**CITY OF ALBUQUERQUE  
PLANNING DEPARTMENT  
December 10, 2014  
DRB Comments**

**PROJECT # 1010168**

**RE: Tracts A and B-4, Lands of Road Runner Investors**

SUBDIVISION PLAT

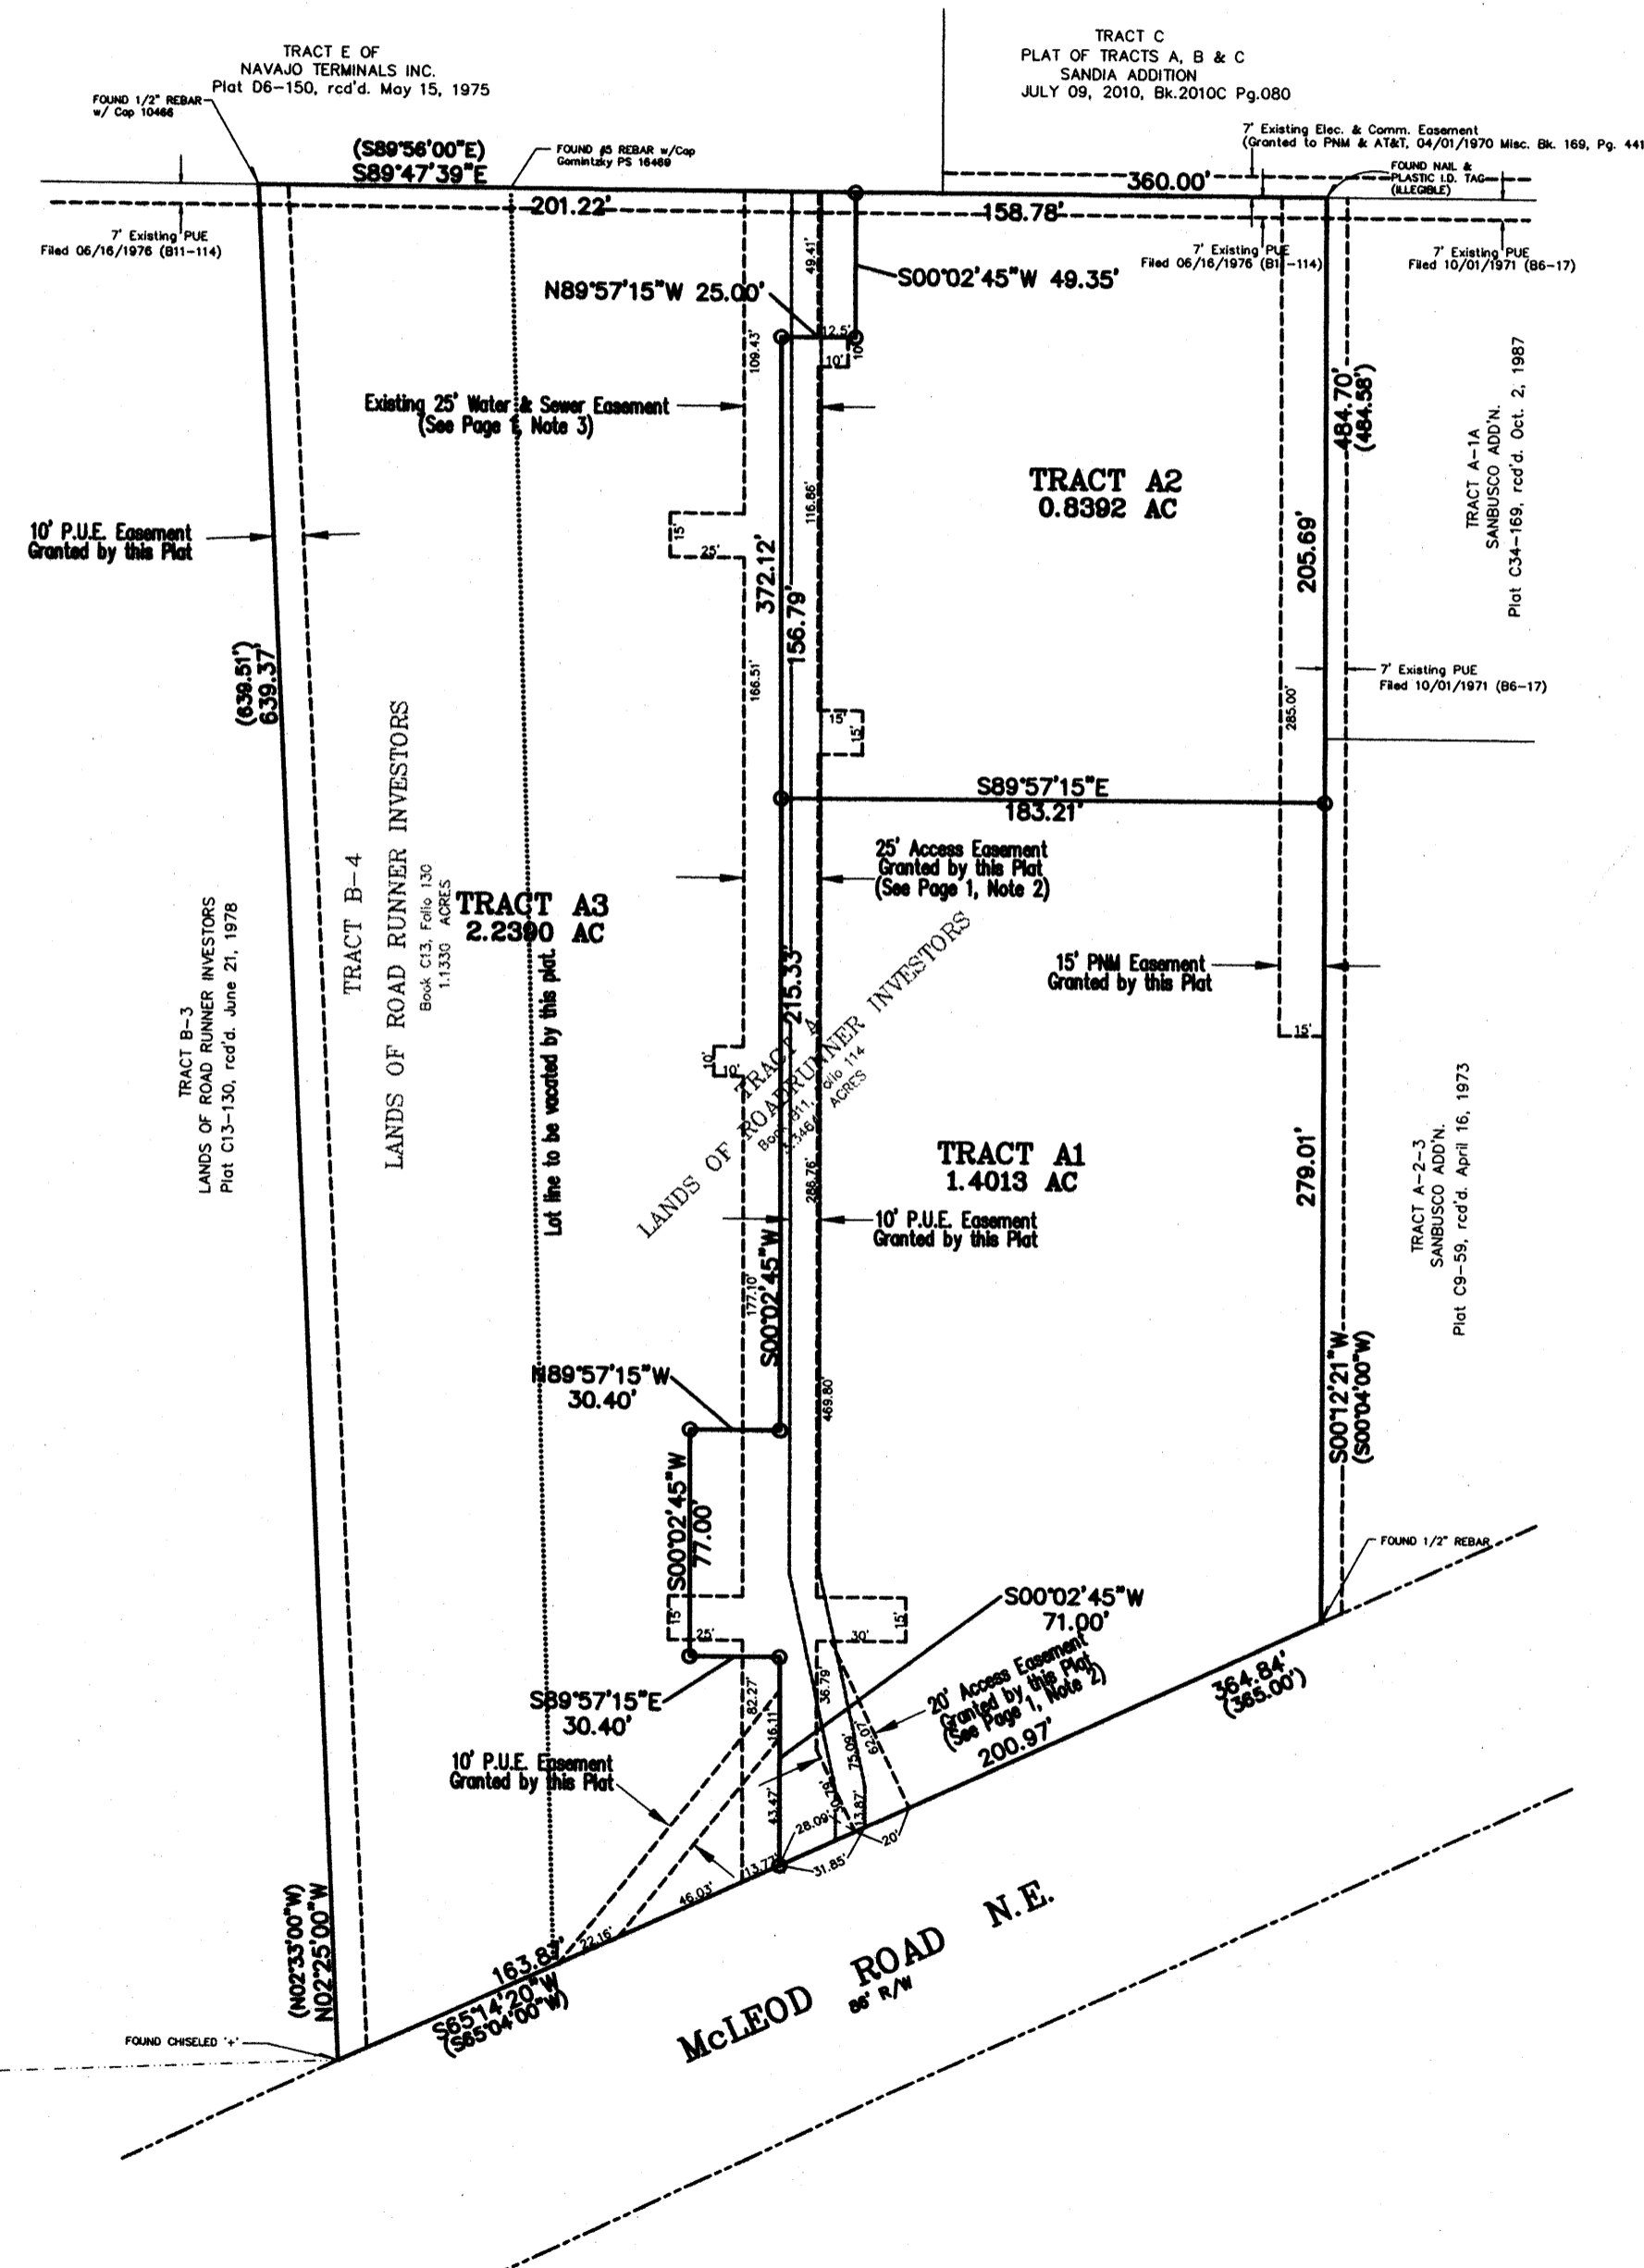
Submitted existing parking for proposed Office Building Tract A1 (89) is not consistent with aerial photography (74) and is not even match submitted site plan (80); there could be an abundance of parking on proposed Tract A2 if properly designated, but as noted in Sketch Plat comments a parking easement does not qualify for meeting Zone Code requirements. Easements need to clearly designate beneficiaries and be consistently noted; it is not clear that proposed Tract A2 can use the main drive.

PROJECT: 1010168
DATE: 7-30-14
APP: 4-70258(SK)

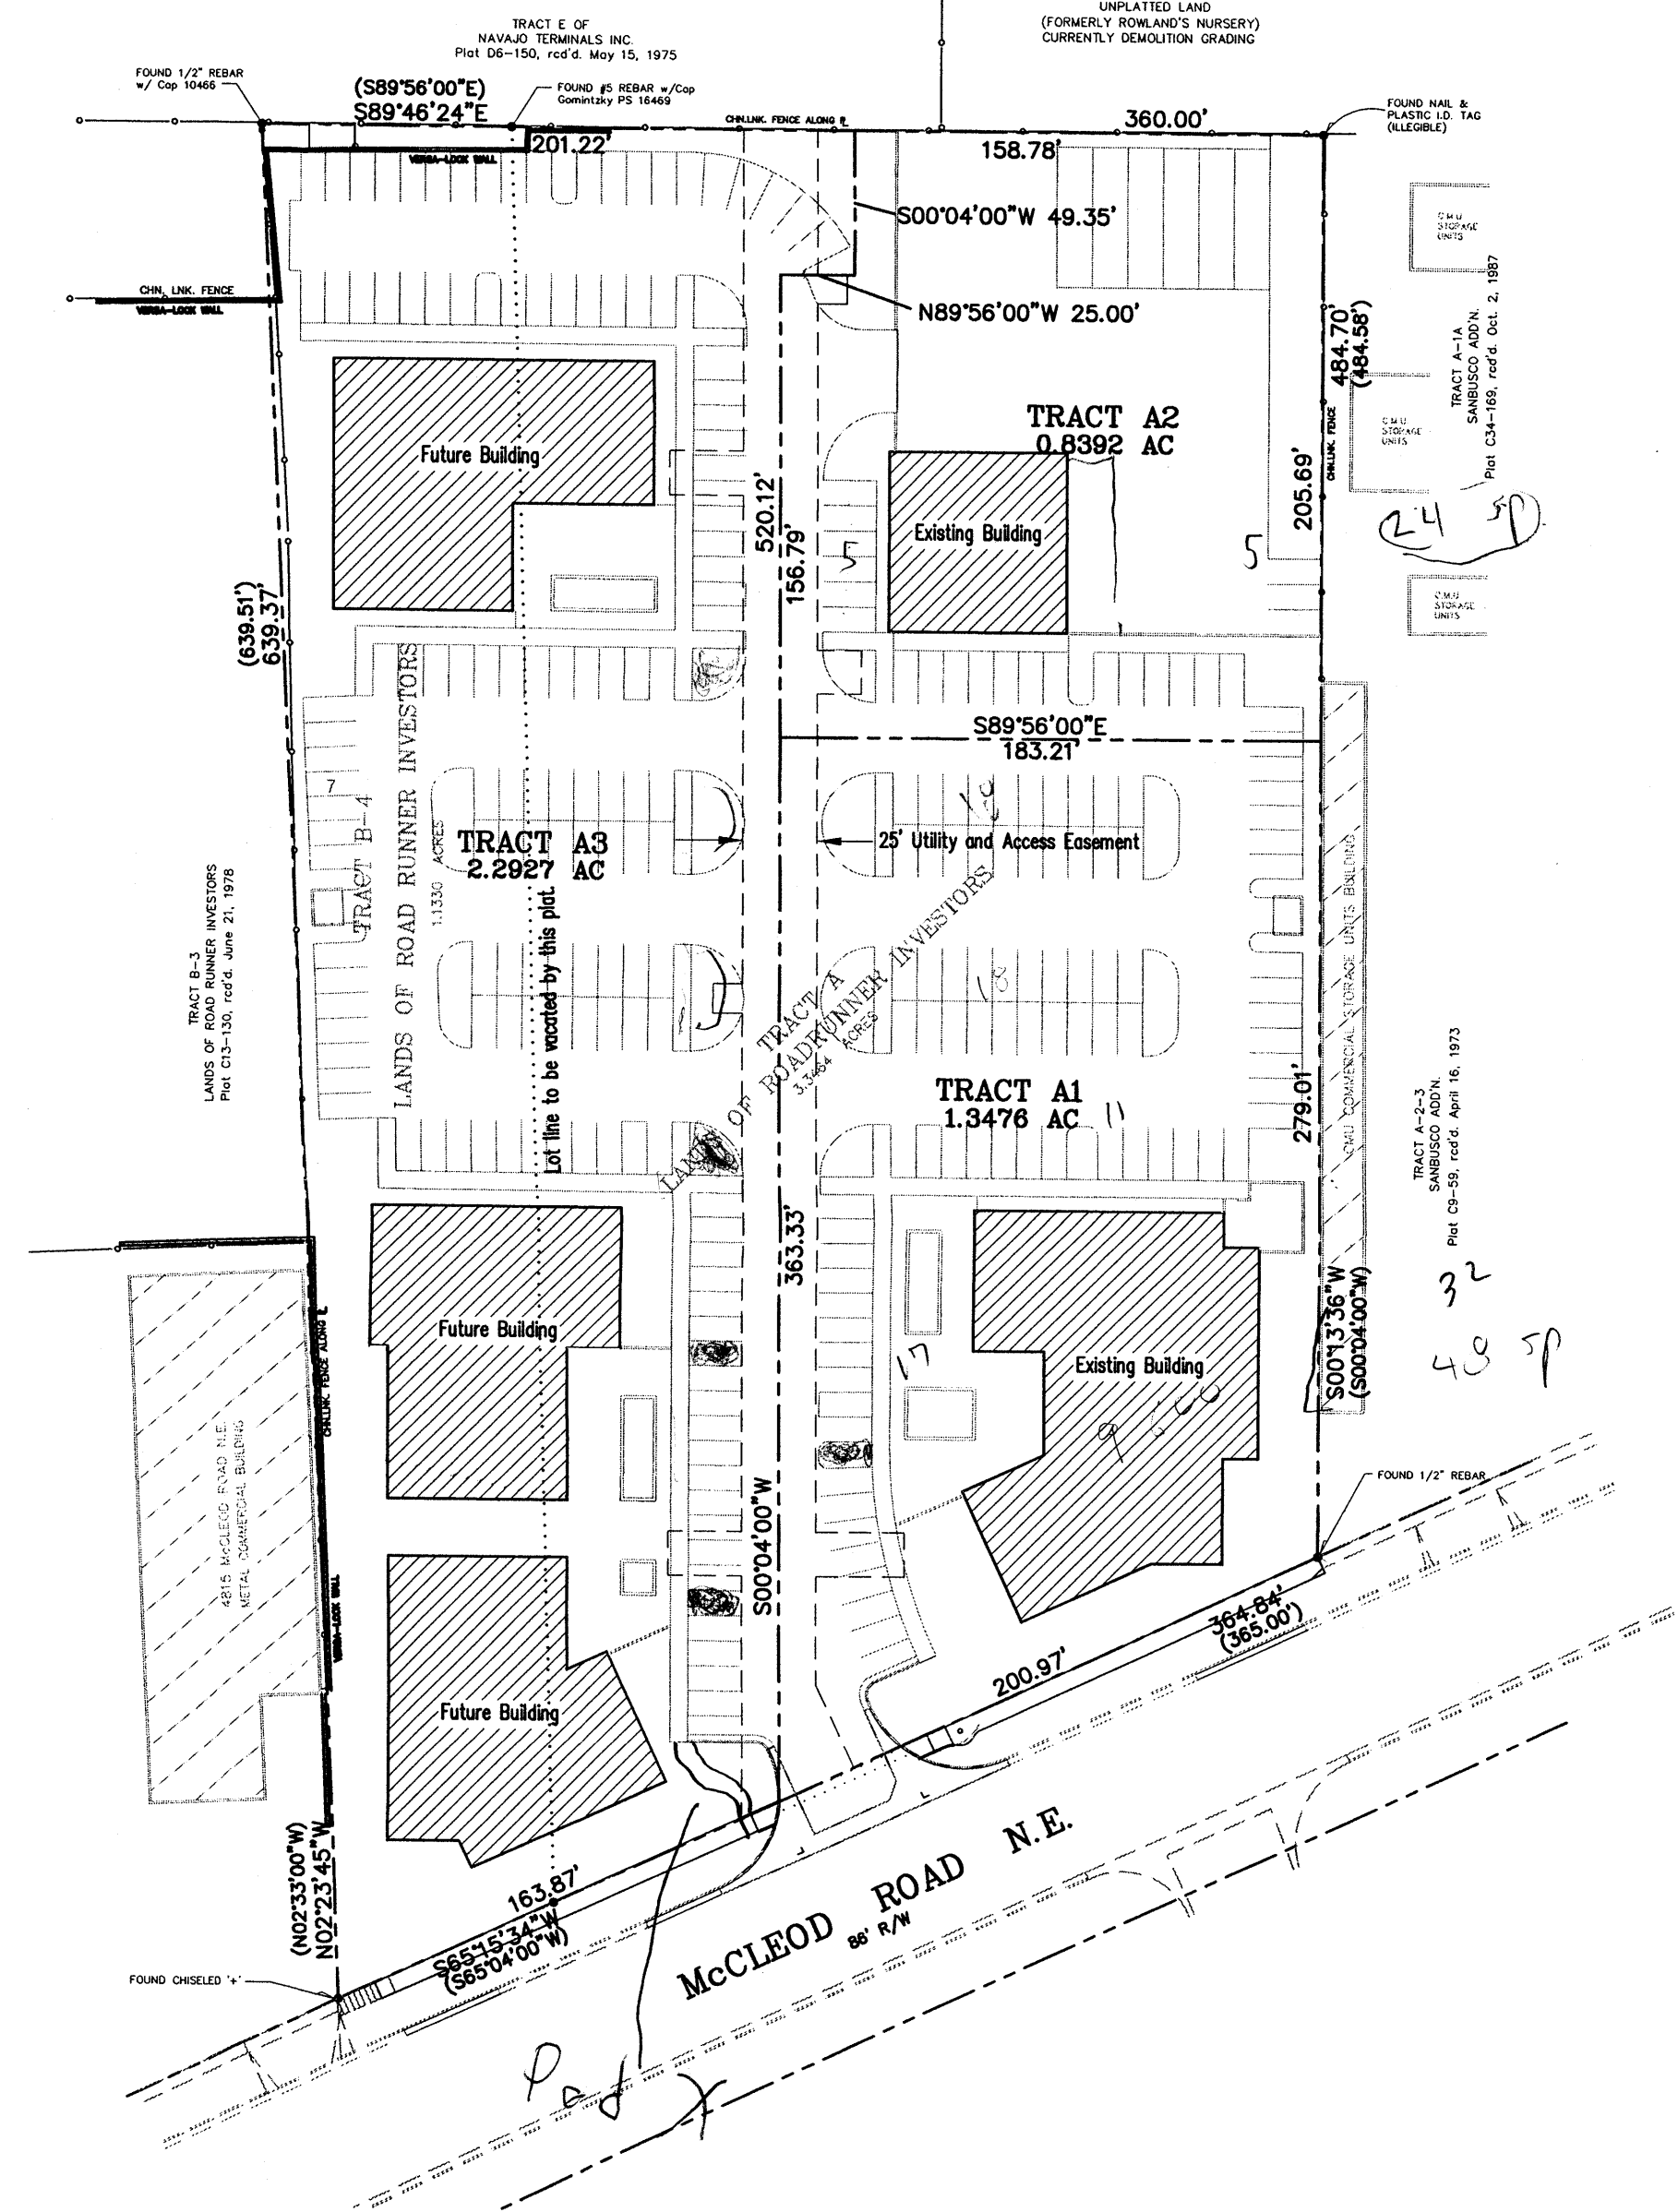
Parking calculations need to be provided to demonstrate that requirements can be met on each new lot; reciprocal parking easement is recommended, but it cannot be counted towards minimum requirements.

Proposed access easement doesn't fit drive aisle (see north and south terminus).

While not a requirement of platting, please note that the sidewalk *along the west side of the drive aisle needs to connect to the public sidewalk on McLeod.*
